City of Albuquerque Stormwater Construction Site Inspection Report

General Information					
ESC File No.	G11E058	Project Name:	Sequoia Apartments		
NPDES Id. No.	NMR1005BW	Location:	5130 Sequoia Rd. NW		
1/2/2026	Owner	Contractor			
Operator	Nouri Apartments	J&S Development Inc.			
Contact name & title	Esmail Haidari	Jose Rodriguez			
e-mail	EsmailHaidari060@gmail.com	Rodriguez3003@hotmail.com			
Contact Phone #	505-250-6088	505-440-5104			
COA Inspector	Chancellor English	Start/End Time:	9:30am		
Construction Phase:	Interiors				
Type of Inspection:	Regular	Storm Event	Post Storm Event >0.25"	311/Complaint	Follow Up
Weather at time of inspection?	Cloudy		Temperature: ~	50	
Estimated date of last storm 0.25" or greater	11/20/2025

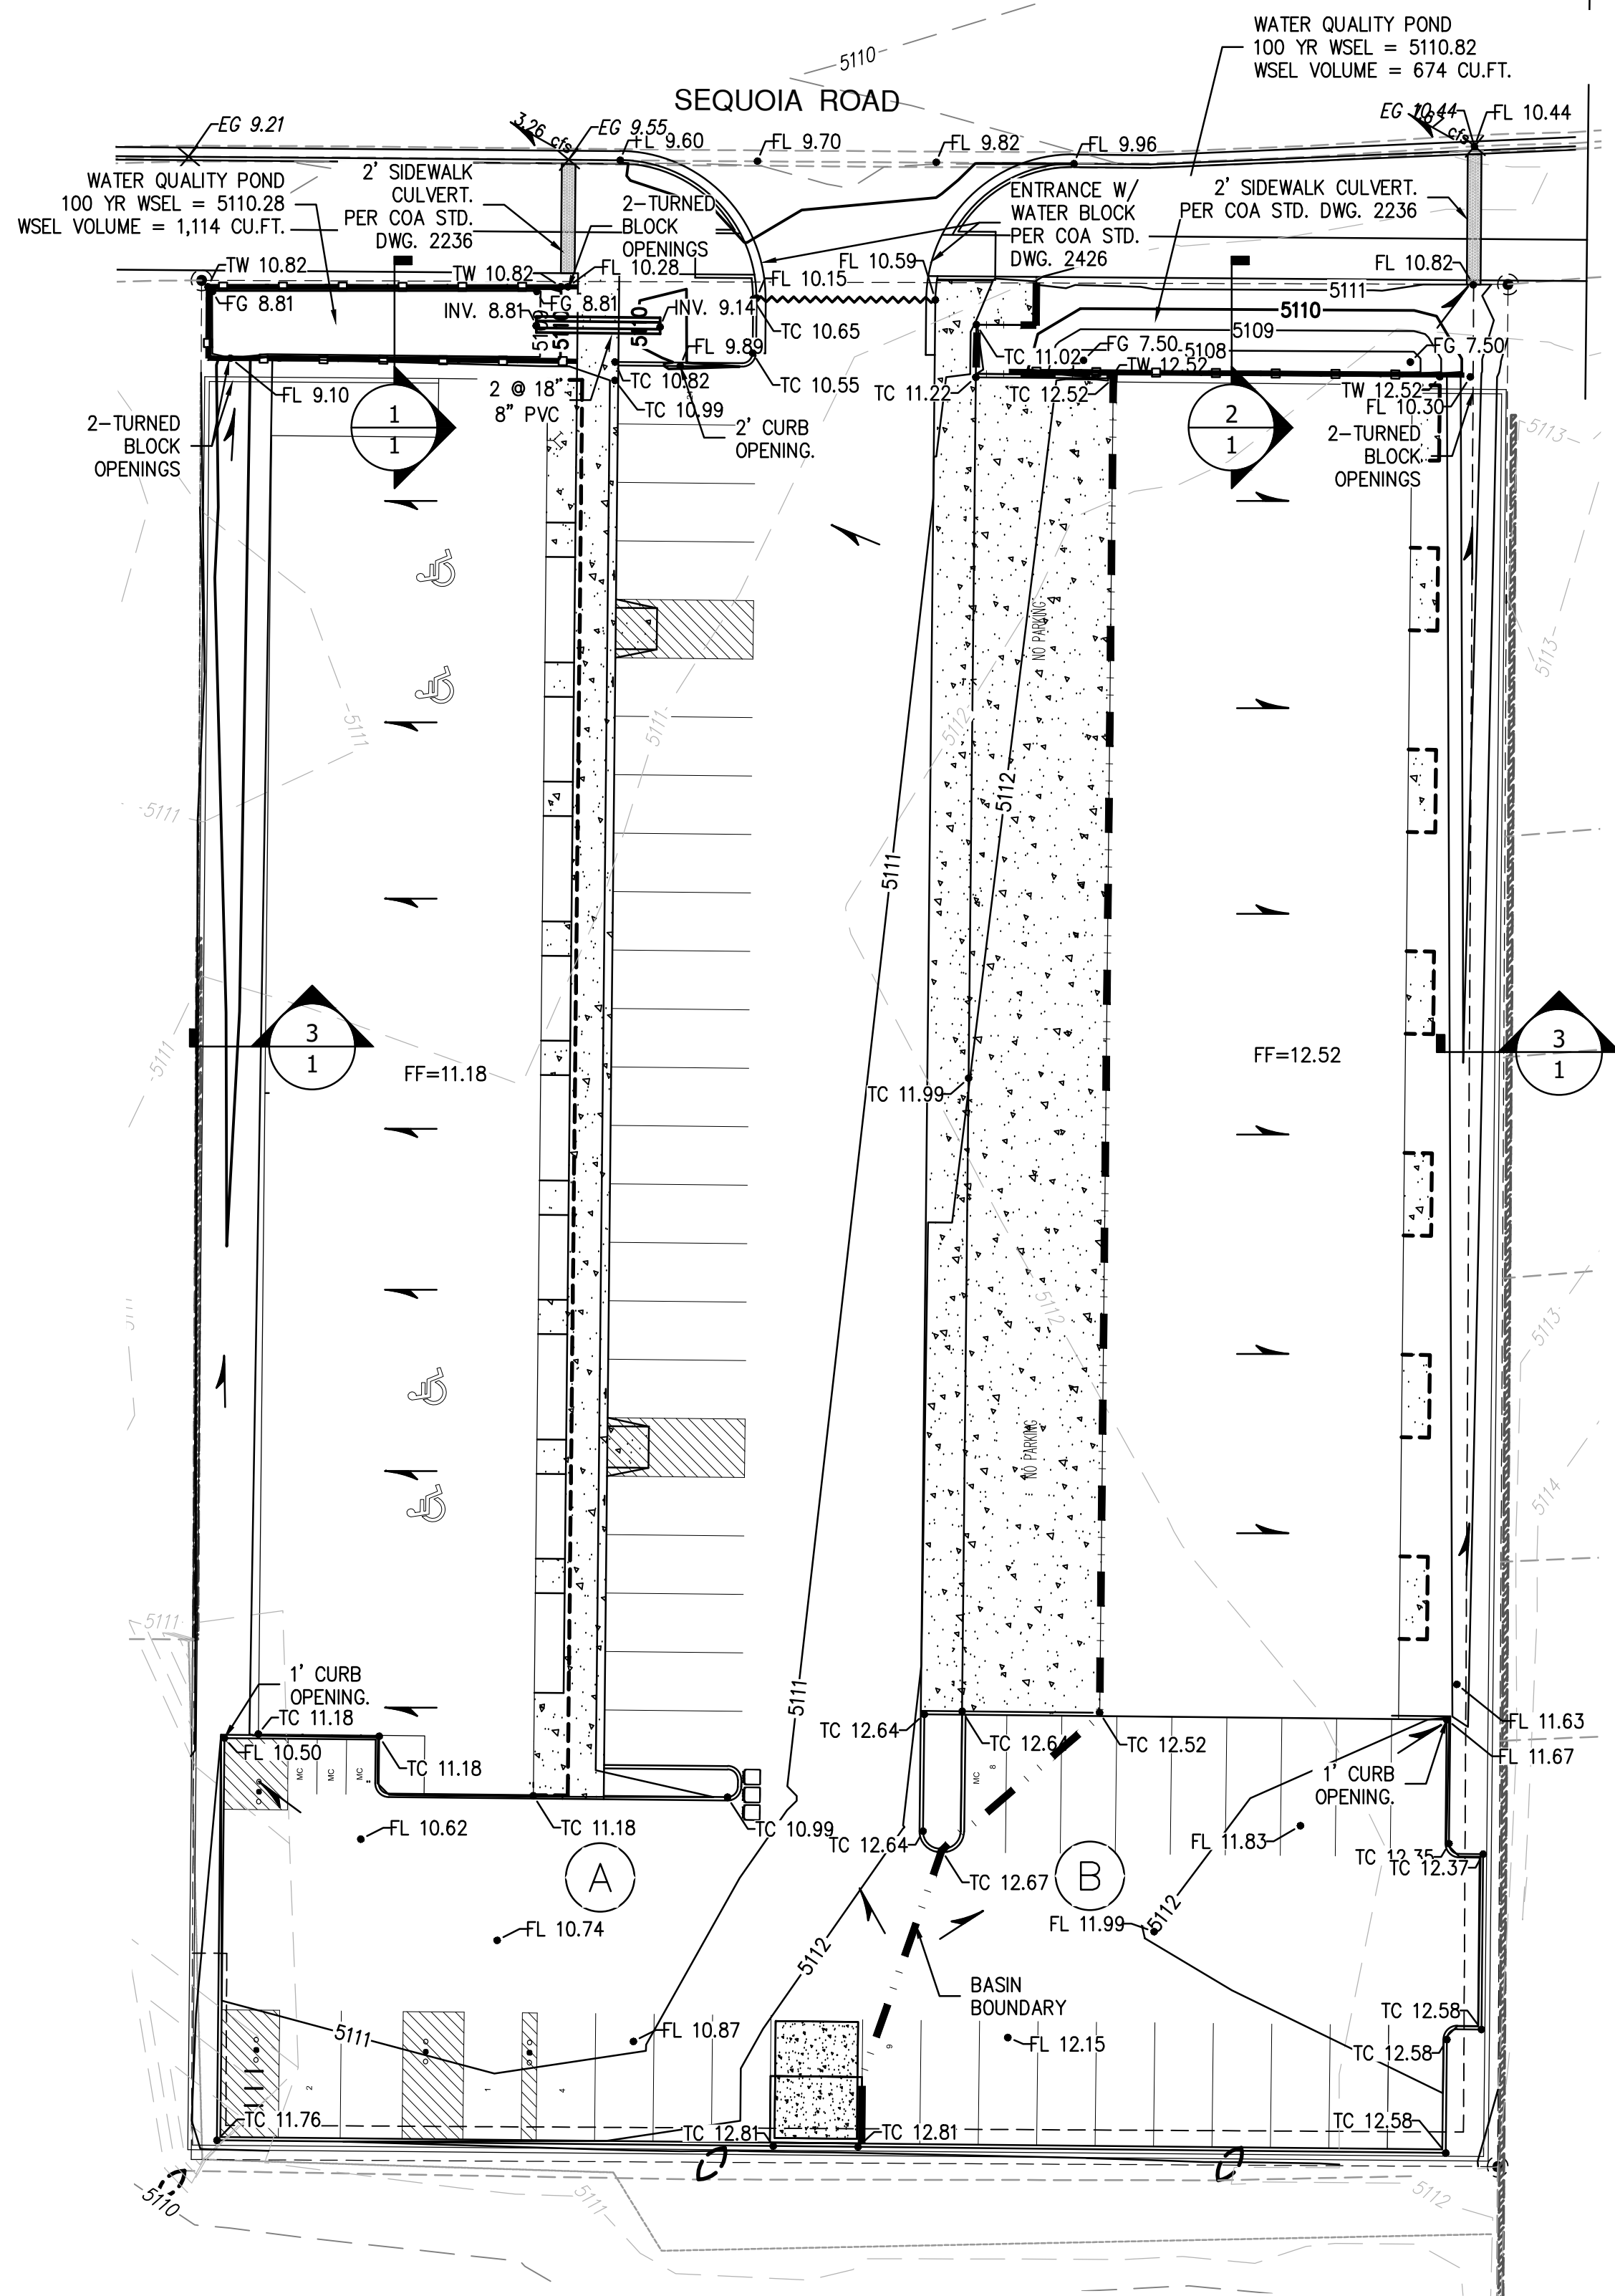
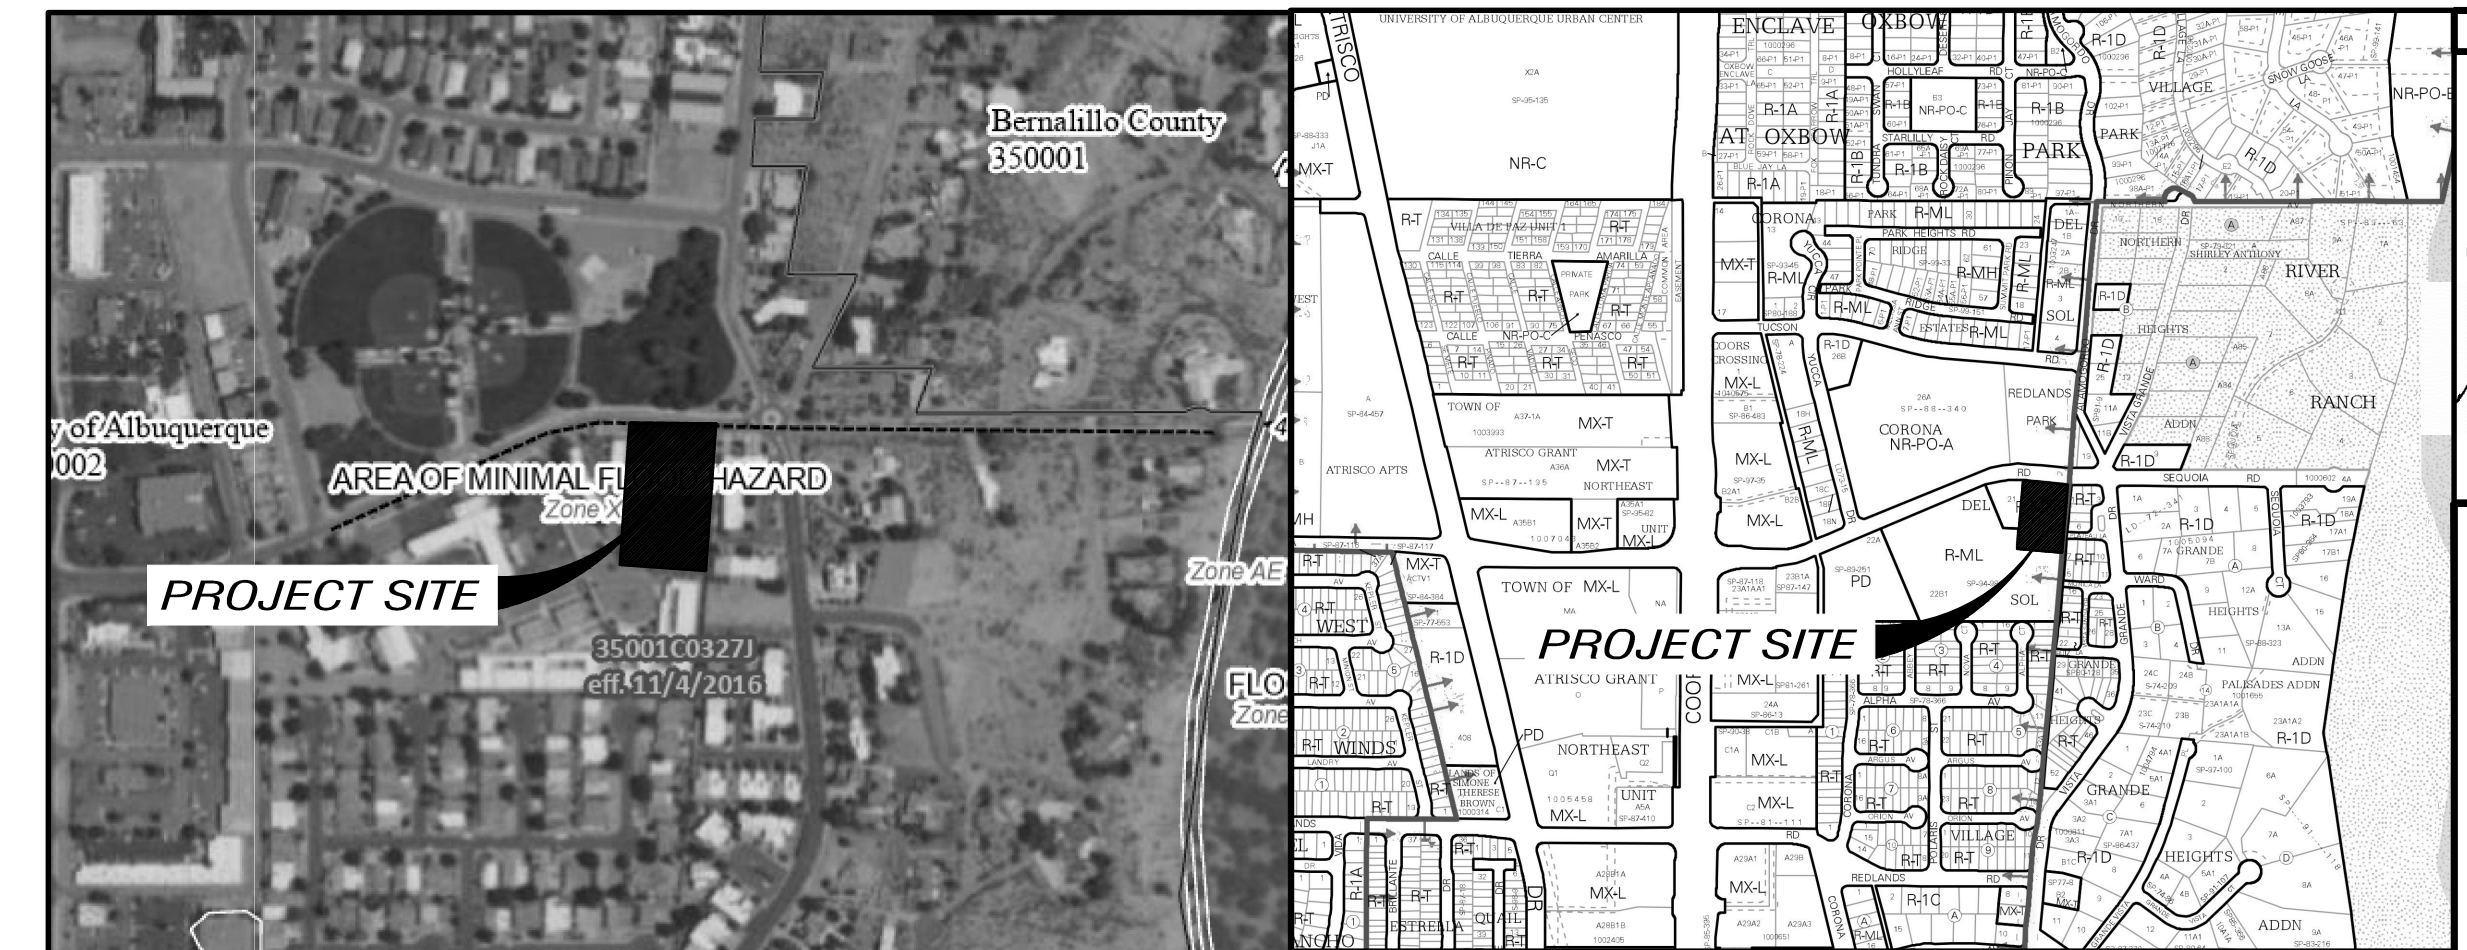
Item Number	Deficiency/ Corrective Action				
1	BMPs - The stormwater quality ponds shown on the approved ESC Plan have not been installed in violation of CGP Part 2.1.3. Required mitigation: Complete installation of stormwater controls by the time each phase of construction activities has begun per CGP Part 2.1.3.
